Project# 21-1146

At your request, a structural inspection of a deck of the house located at 80 Doonbeg Dr Fuquay-Varina, NC was performed on 05/14/2021 to evaluate the as-built deck in the rear side of the house.

Following repairs are needed to meet the NCRC 2018 requirements:

80 Boonberg Dr
 Furry-Verm, NC, 27526
 Site plan.
 Construction: Deck Extension.

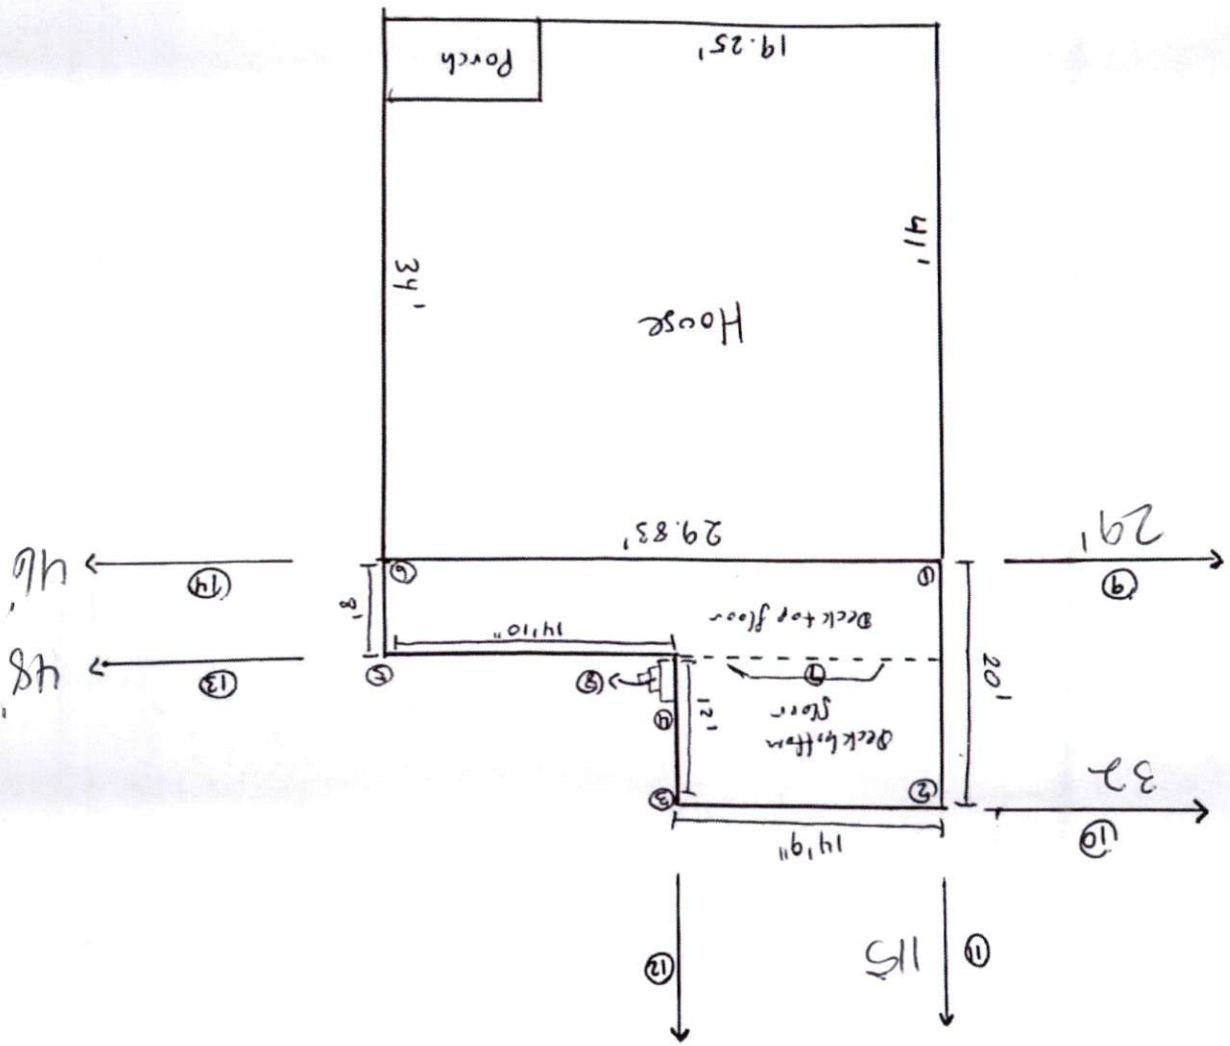
1. The right rear corner post of the elevated deck shall be removed and two 6x6 posts shall be installed at a minimum distance required by the town for septic line. We recommend that you install two posts on the two sides of the deck, 18 inches away from the current position. The footing shall be 18"x18"x16" concrete for each post. (2) 2x beam may be left as is making cantilever. The beam(s) shall be connected to new posts using 2 thru bolts. See attached picture for reference.

3. Since the deck is more than 4 feet height, install 2x6 bracing on the elevated deck post lines and outmost deck posts using a 5/8" diameter thru bolts. See attached picture for reference.

4. The rear right corner post of the lower deck shall be removed and two 6x6 posts shall be installed about 3 feet to maintain minimum distance from the septic line. Install Knee brace on both sides to support deck beams. See attached picture for reference.

5. 4x4 rail post cannot be notched. Replace all notched rail posts by 4x6 post ensuring the bolted post side is 4" (nominal).
6. The single beam(2x) for the lower deck is inadequate for the provided deck span. We recommend that you install a (2)2x10 girder in the mid span bolted through the two existing posts and new 6x6 posts in the middle. Footing shall be 18"x18"x16" concrete.
